CITY OF ALBUQUERQUE

March 30, 2023

Re: Sonic # 1091
Southeast side of 98th St. and Bluewater Rd.
Traffic Circulation Layout
Engineer's/Architect's Stamp XX-XX-XX (K09-D048C)

Based upon the information provided in your submittal received 03-10-23, the above referenced plan cannot be approved for Building Permit until the following comments are addressed:

SITE PLAN

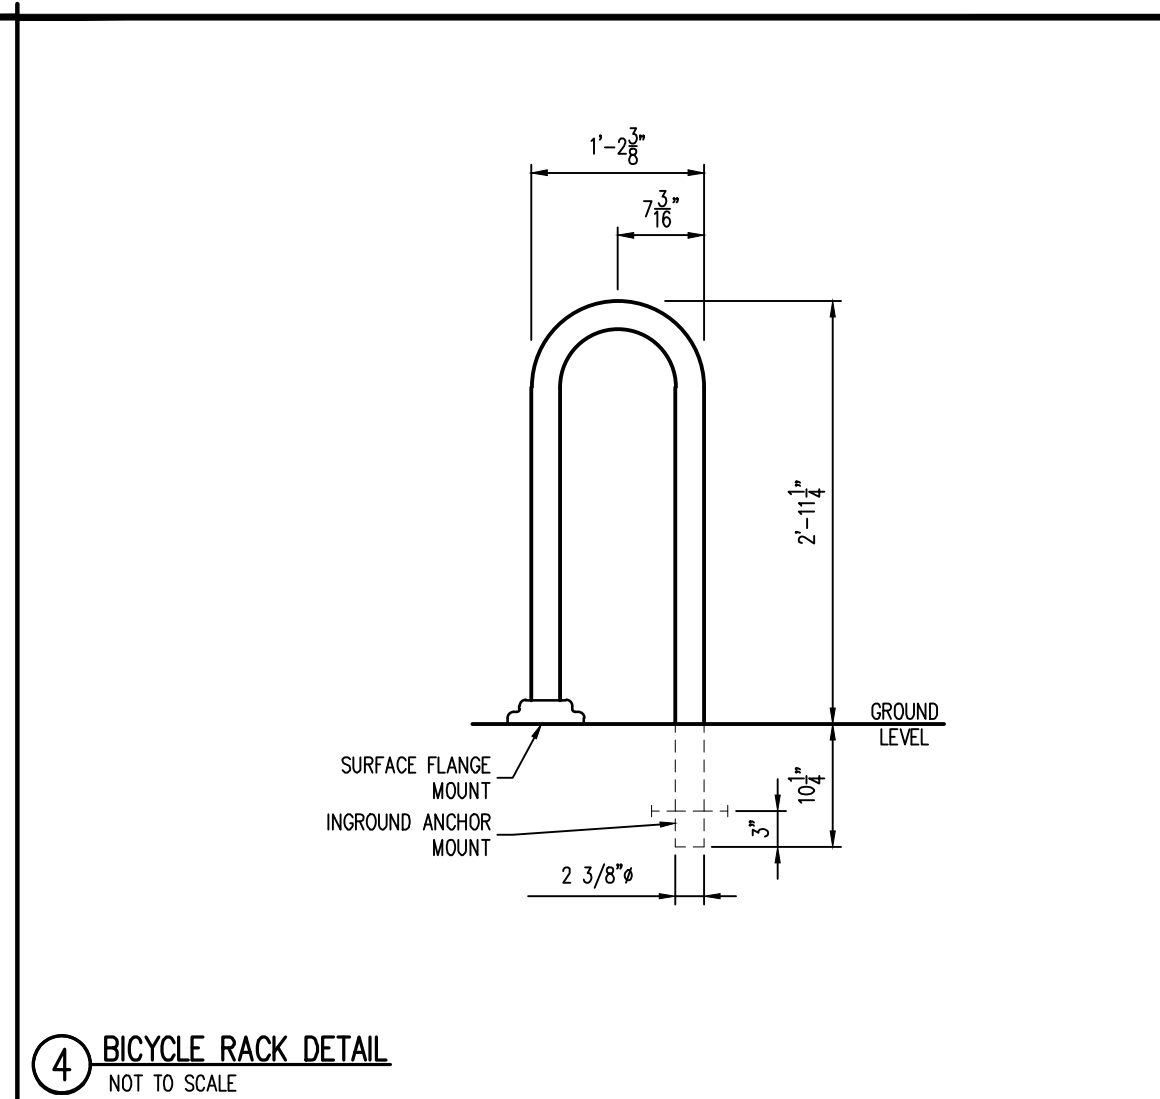
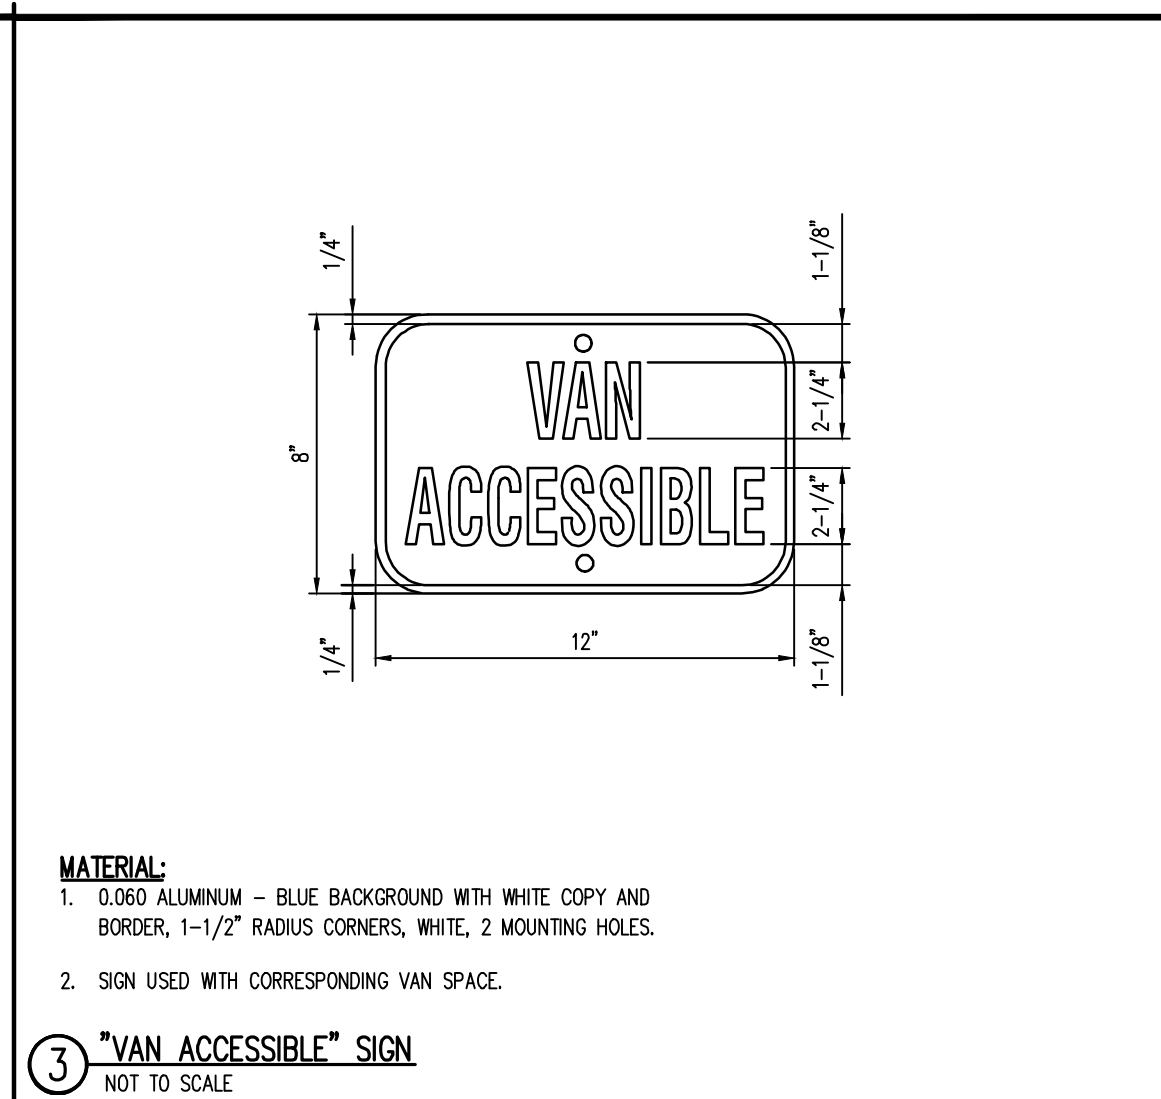
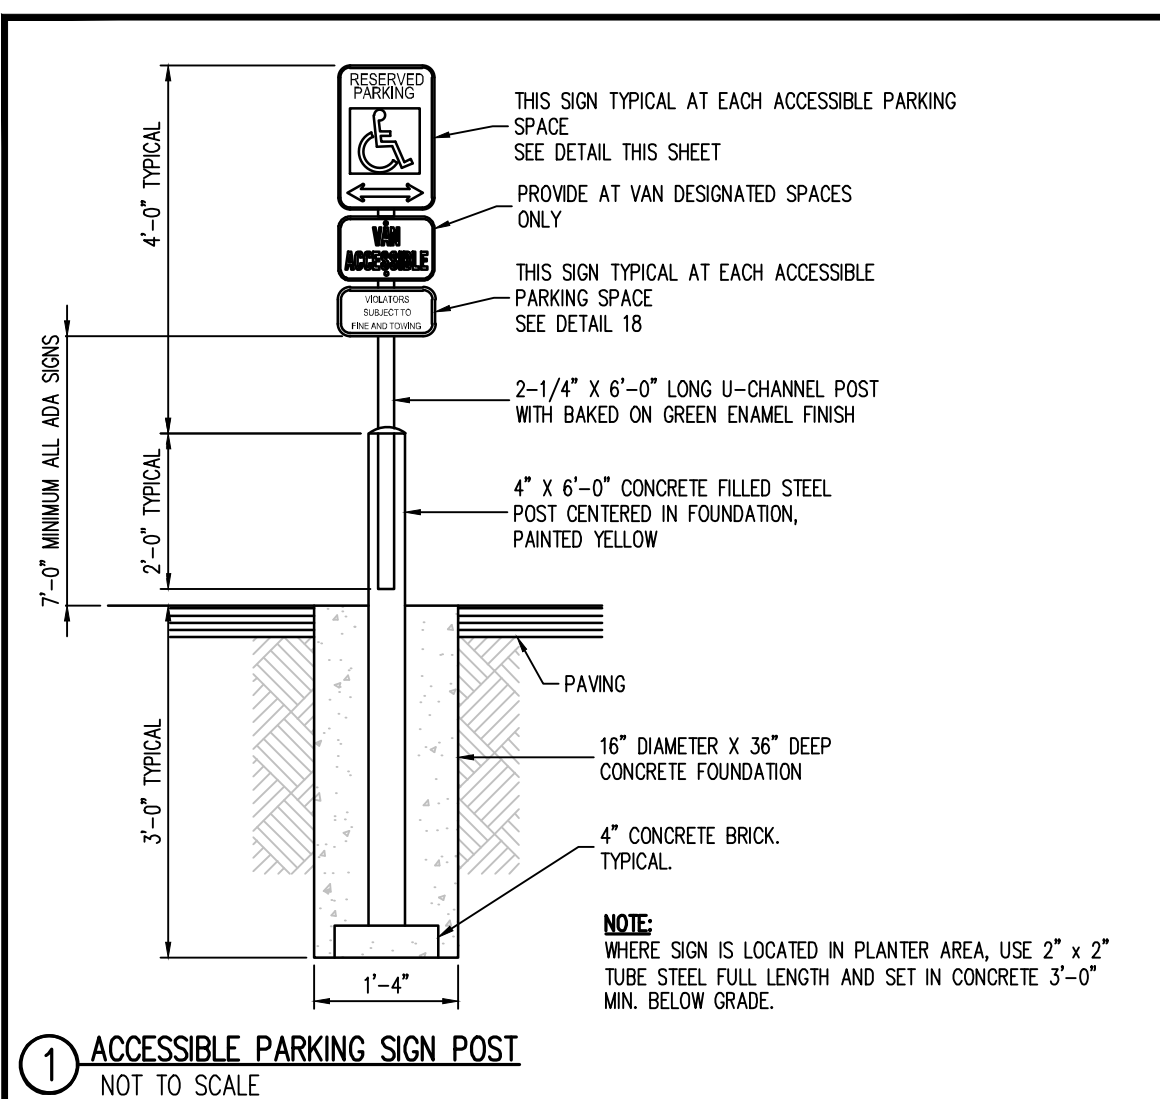
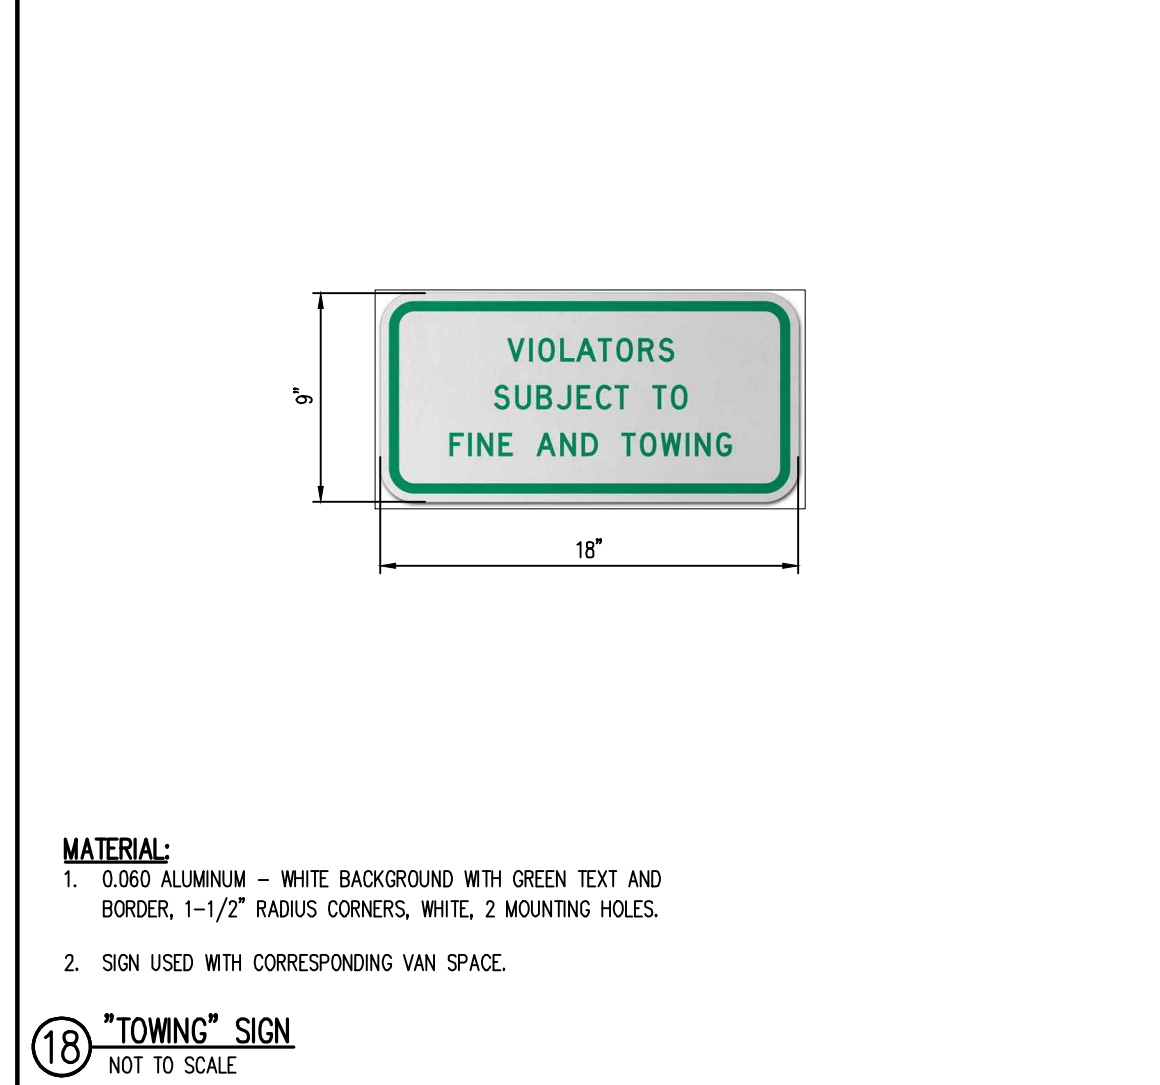
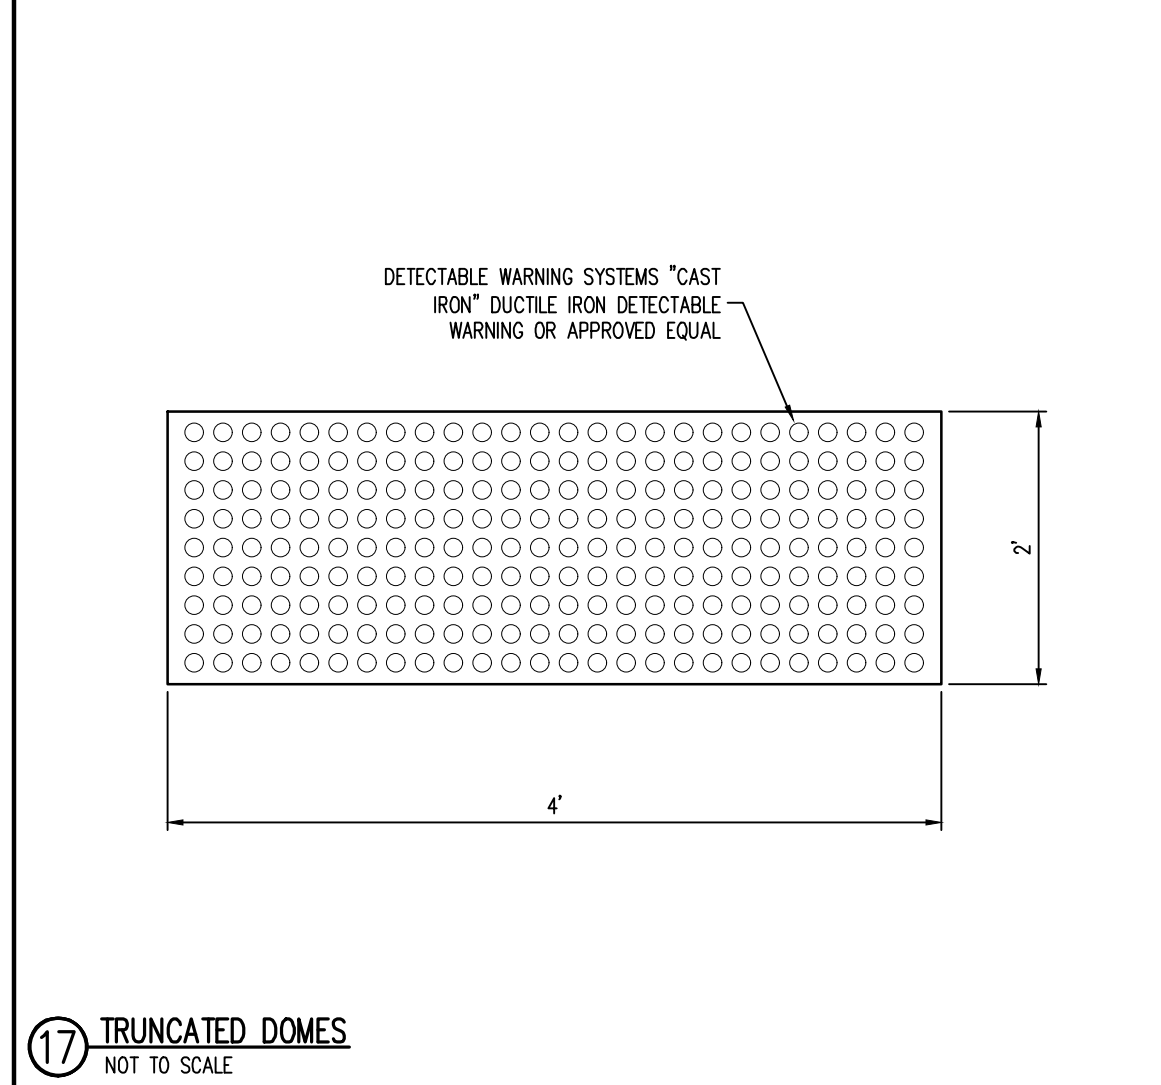
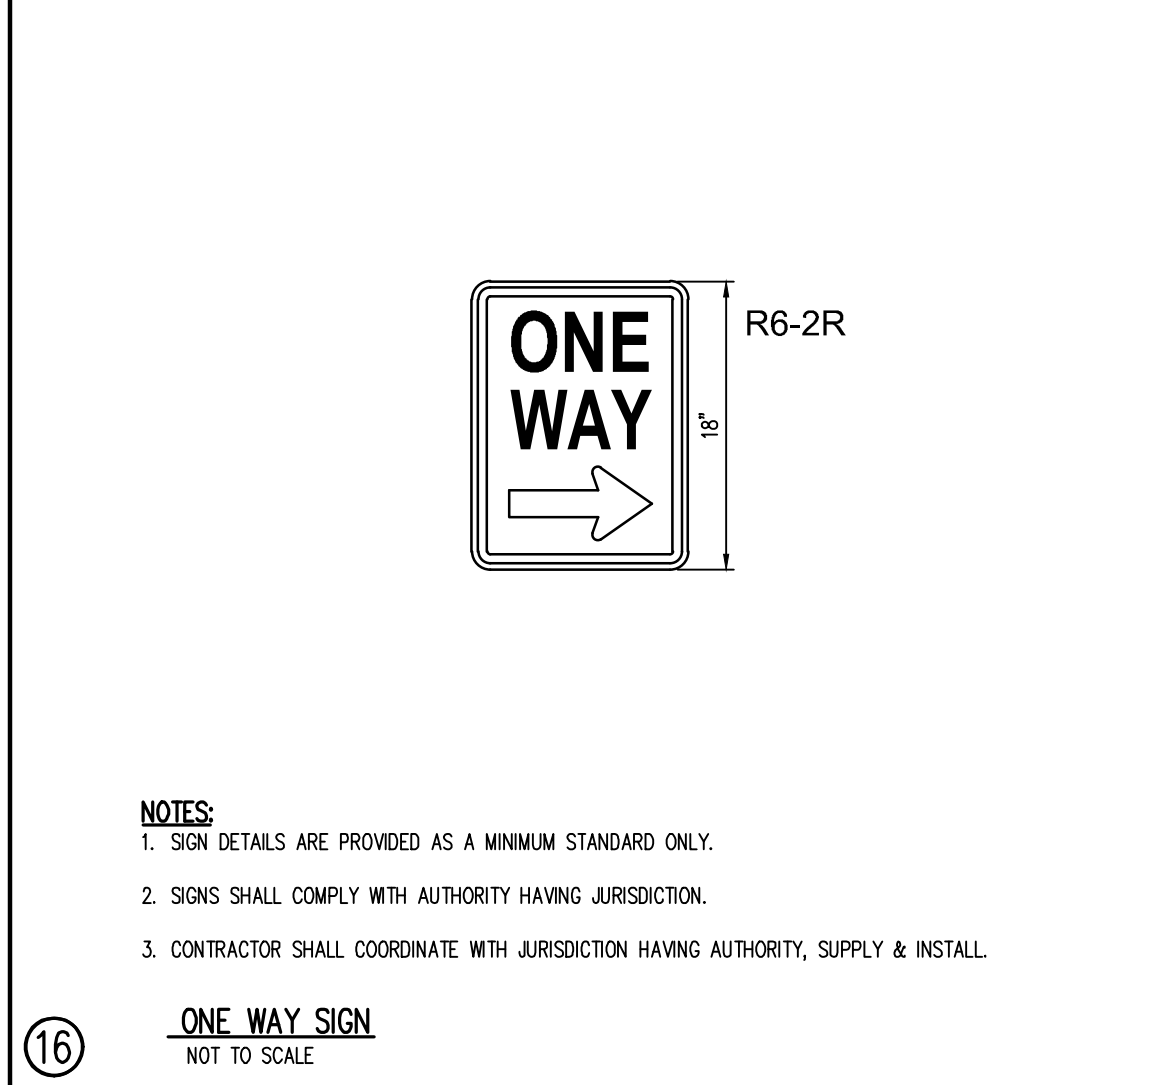
1. Please show a vicinity map showing the location of the development in relation to streets and well-known landmarks.
2. List the number of parking spaces required by the IDO as well as the proposed number of parking spaces including bicycle and motorcycle parking.

3. The traffic circulation layout must be stamped, signed, and dated by an engineer or architect licensed in the state of New Mexico.
4. Identify all existing access easements and rights of way width dimensions.

5. Please define the property line.
6. Provide shared access agreement or approved plat showing the existing 33' access easement at the east side of the site.

7. Provide the angle for the angled parking. See attached angle parking stall requirements.
8. Provide details for all the proposed interior ADA ramp.
9. The ADA accessible parking sign must have the required language per 66-7-352.4C NMSA 1978 **"Violators Are Subject to a Fine and/or Towing."** Please call out detail and location of signs.

10. The ADA access aisles shall have the words **"NO PARKING"** in capital letters, each of which shall be at least one foot high and at least two inches wide, placed at the rear of the parking space so as to be close to where an adjacent vehicle's rear tire would be placed. (66-1-4.1. B NMSA 1978)

11. ADA curb ramps must be updated to current standards and have truncated domes installed.
12. Motorcycle parking spaces shall be designated by its own conspicuously posted upright sign, either free-standing or wall mounted per the zoning code.

13. The pavement marking "MC" should be shown in the opposite direction for motorcycles entering the parking space.

18. Per the IDO, a 6 ft. wide ADA accessible pedestrian pathway is required from the public sidewalk to the building entrances. Please clearly show this pathway and provide details.

19. Per DPM, a 6 ft. wide ADA accessible pedestrian pathway is required from the ADA parking stall access aisles to the building entrances. Please clearly show this pathway and provide details.

20. ADA accessible pedestrian pathway should not be placed behind parking space or adjacent to a vehicular way. Vehicle and pedestrian/wheel chair conflicts should be avoided as much as possible.

21. Refuse vehicle maneuvering shall be contained on-site. The refuse vehicle shall not back into the public right of way.; provide a copy of refuse approval.

22. Provide a copy of Fire Marshal approval.
23. All one-way drives shall have "One Way" and "Do Not Enter" signage and pavement markings. Please show detail and location of posted signs and striping.

24. The minimum drive through lane width is 12 feet with a 25-foot minimum radius (inside edge) for all turns. (A 15-foot radius can be used with an increase in lane width to 14 feet). Please dimension all lane widths and radii.

25. Show on the site plan the Intersection clear sight triangle at the intersection of 98th St. and Bluewater rd.
26. Show the clear sight triangle and add the following note to the plan: "Landscaping and signage will not interfere with clear sight requirements. Therefore, signs, walls, trees, and shrubbery between 3 and 8 feet tall (as measured from the gutter pan) will not be acceptable in the clear sight triangle.
